Rt. Hon. Secretary of State
Secretary of State for Energy Security and Net Zero
55 Whitehall
London
SW1A 2HP

Our Ref: IP Reference-20053931
Your Ref: EN020028
Please Ask For: Steve Smth
Telephone: [REDACTED]
Email: [REDACTED]@fylde.gov.uk
Date: 07 August 2026

**Morgan and Morecambe Offshore Wind Farms Transmission Assets Development Consent Order
Response to SoS Consultation of 20 May 2026**

Figure 1-1: Environmental mitigation areas at south of Newton-with-Scales

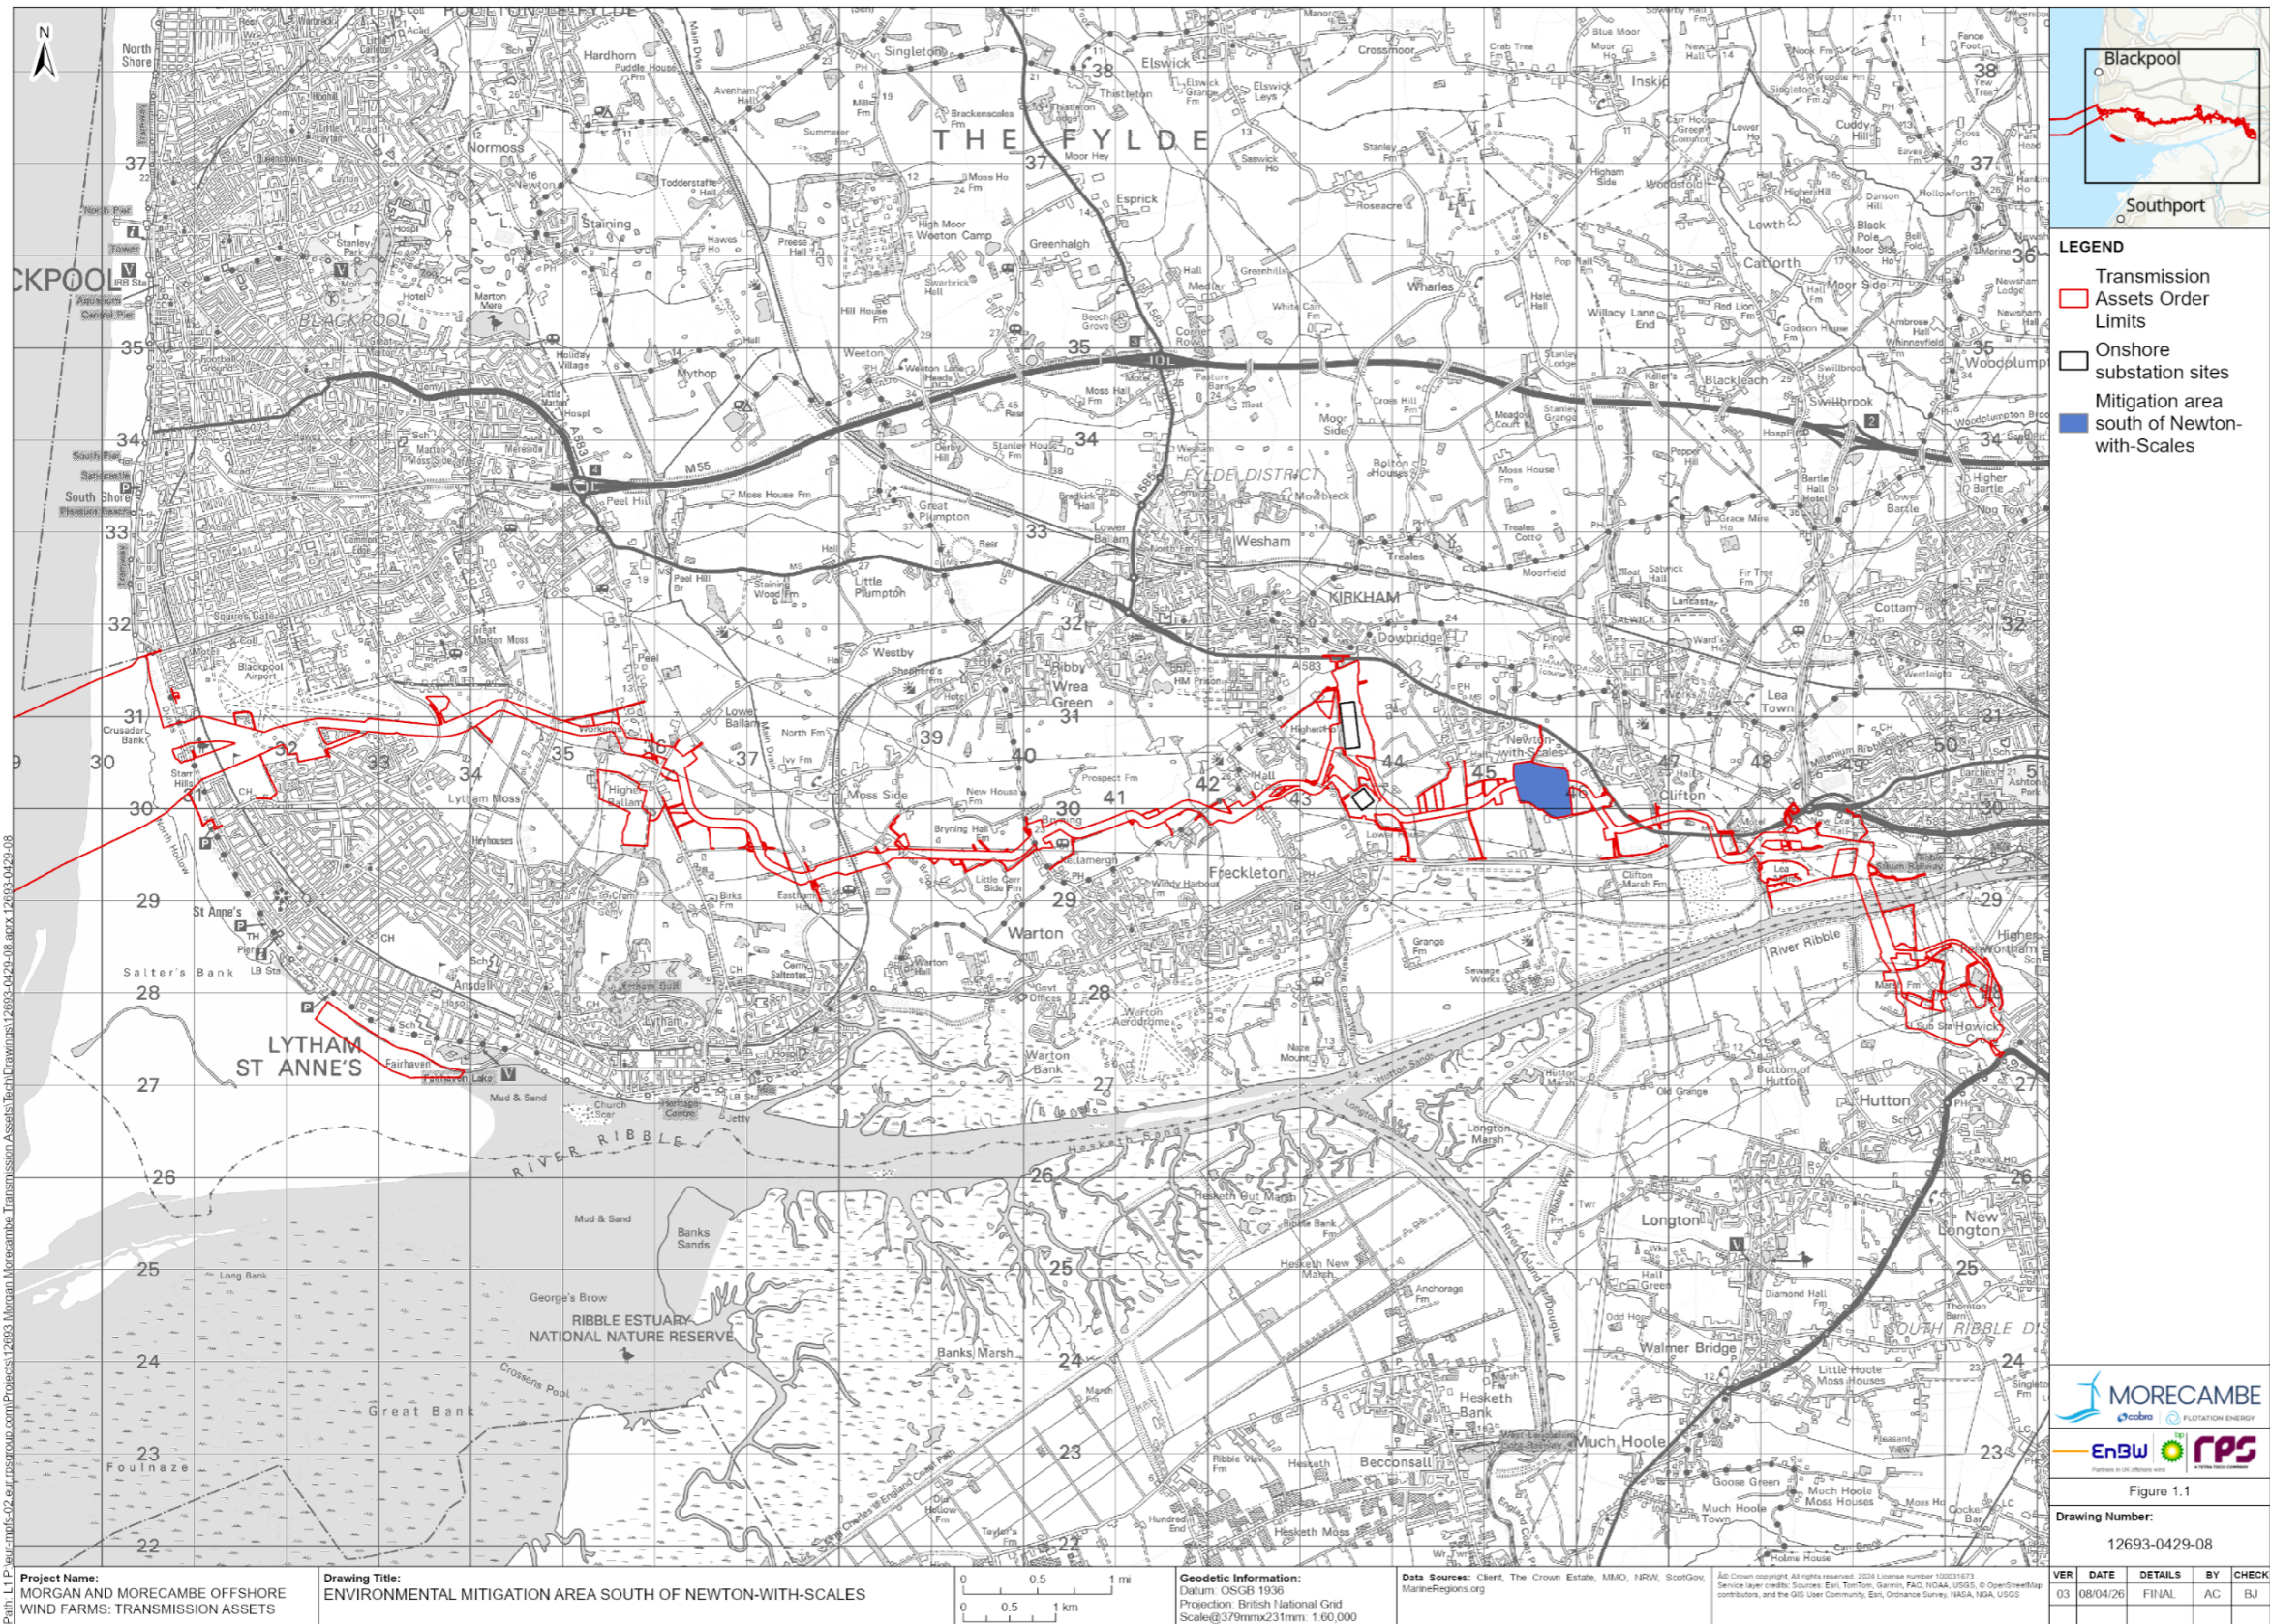
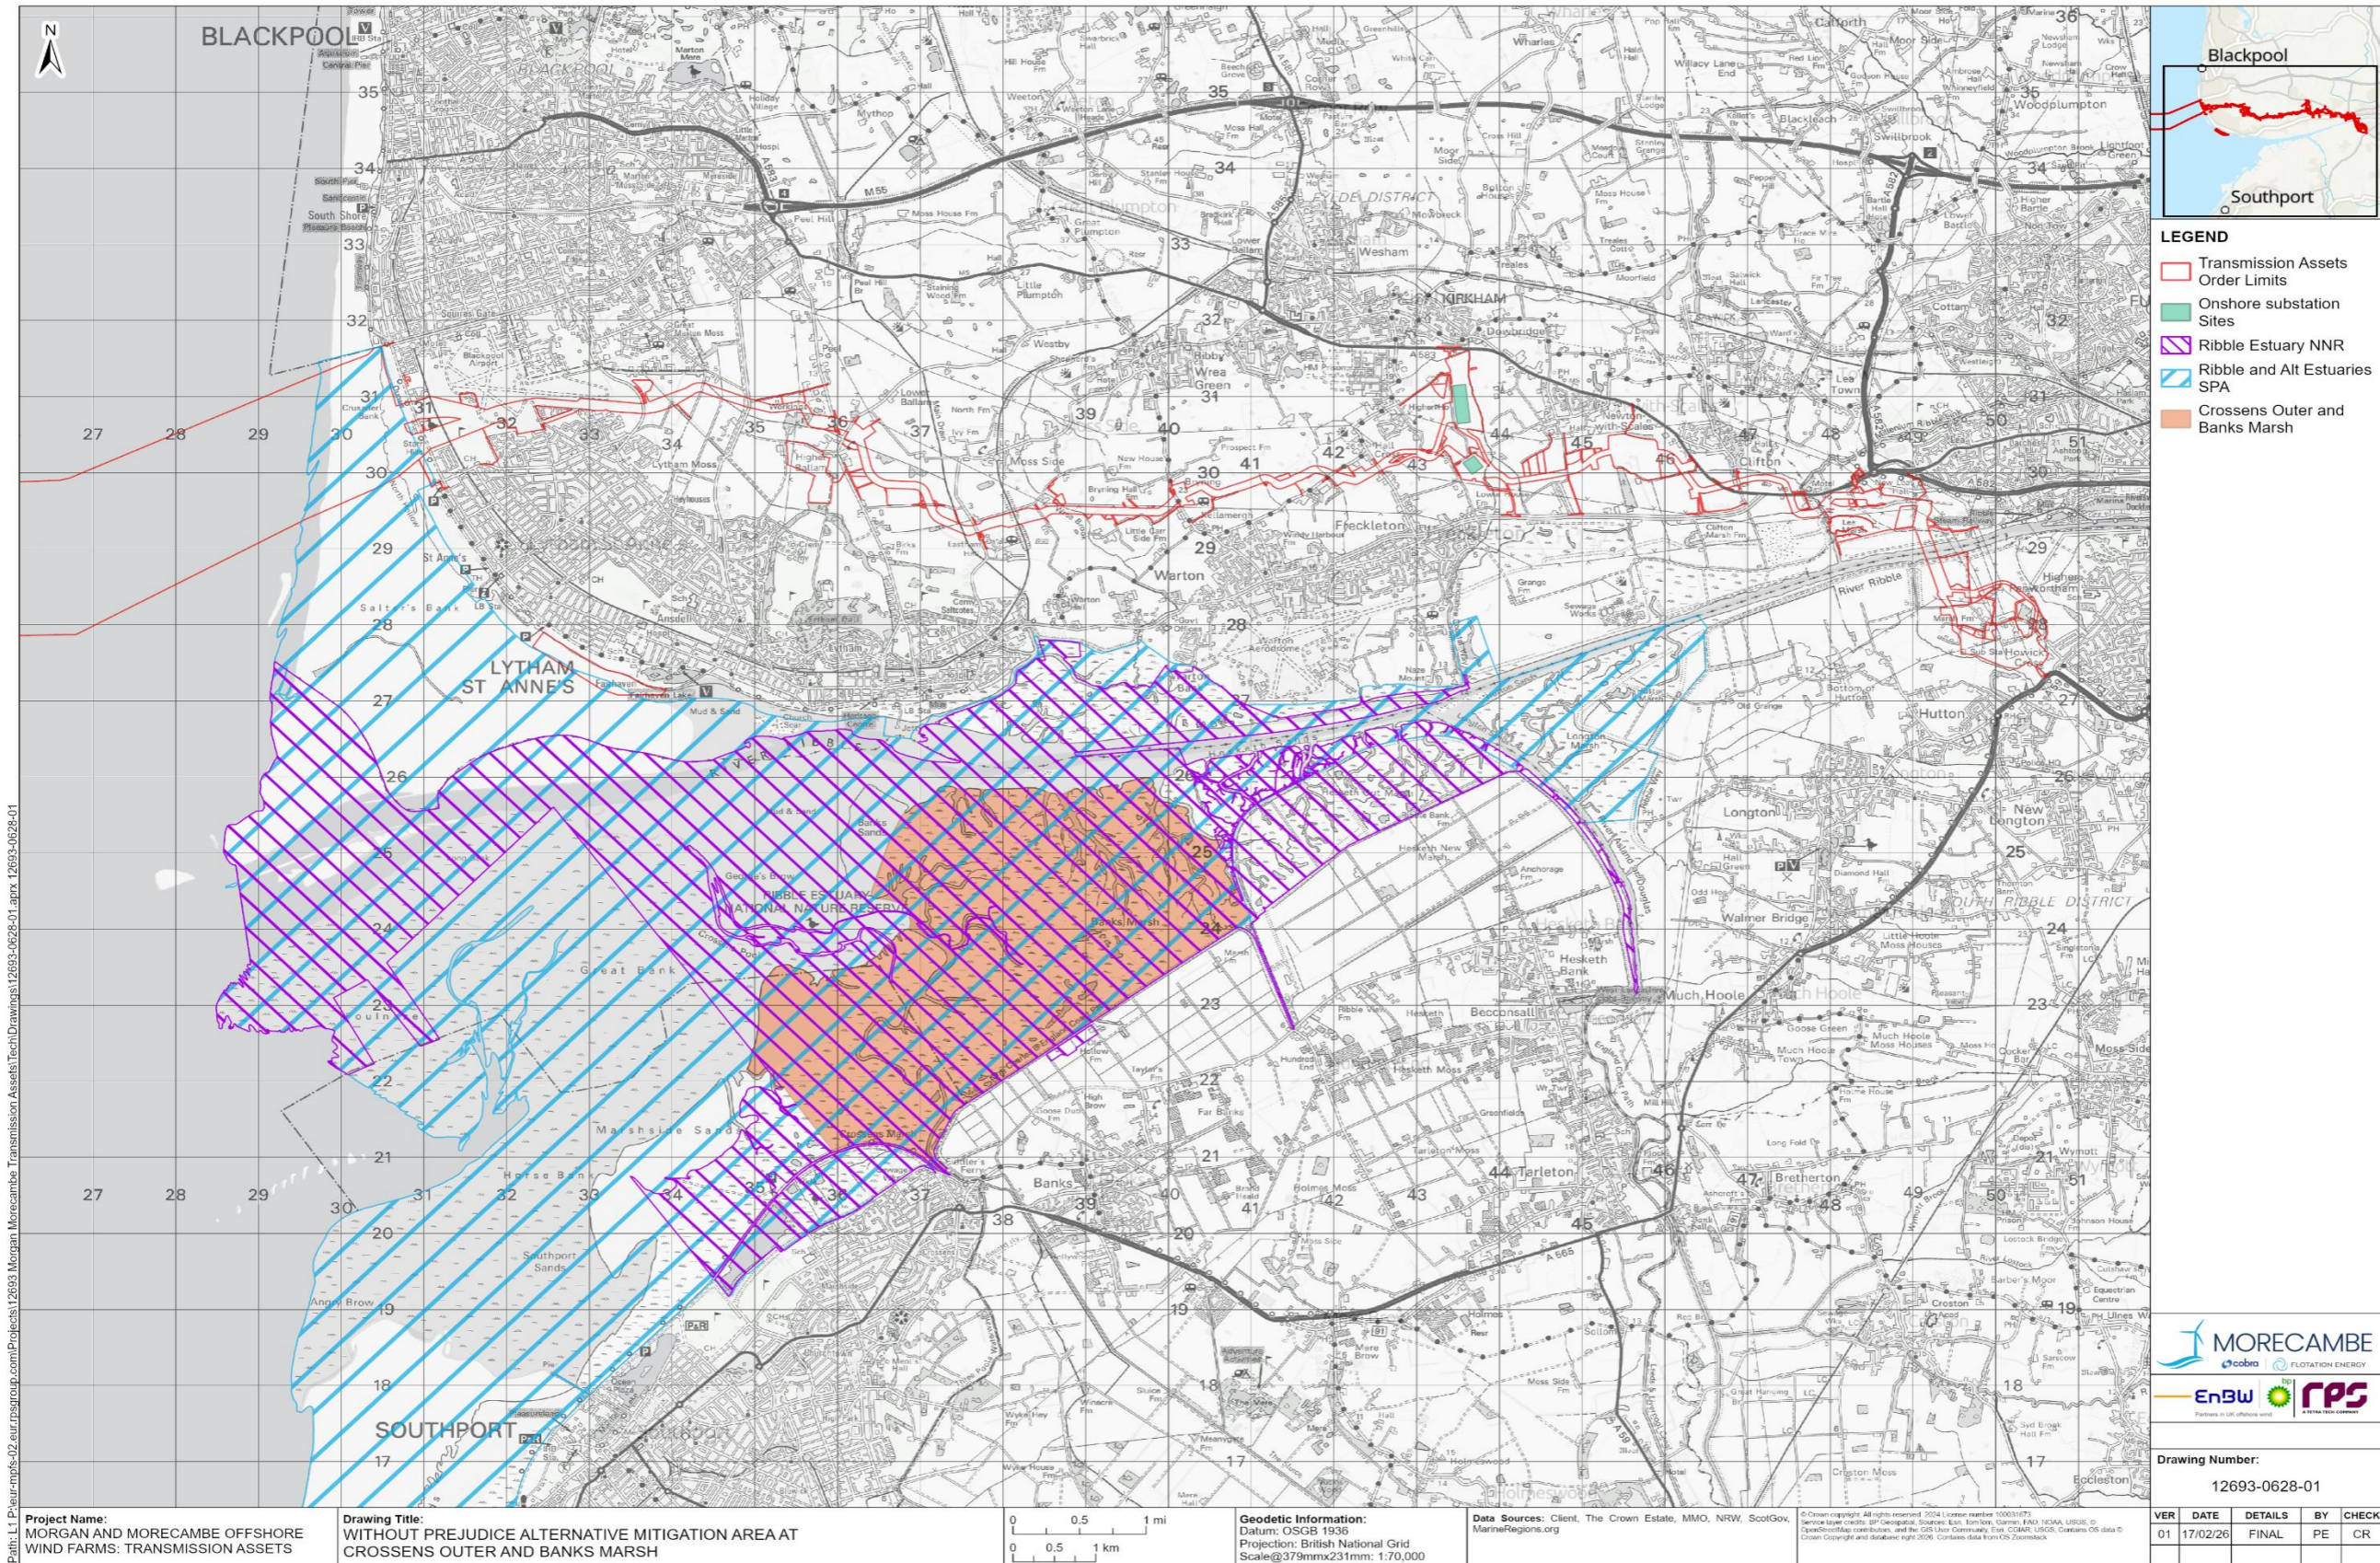
Sections 1.3.2.41 and 1.3.2.49 [C2-092.2] repeated the assertion that NE had agreed that the loss of land would not represent an AEoI but as set out earlier in this response, that assertion was incorrect. For these same reasons, the update to the Alternative Ornithology Mitigation Note [C2-029.23] was flawed, as highlighted by the alleged justification set out in Section 1.1.1.2 of that report.
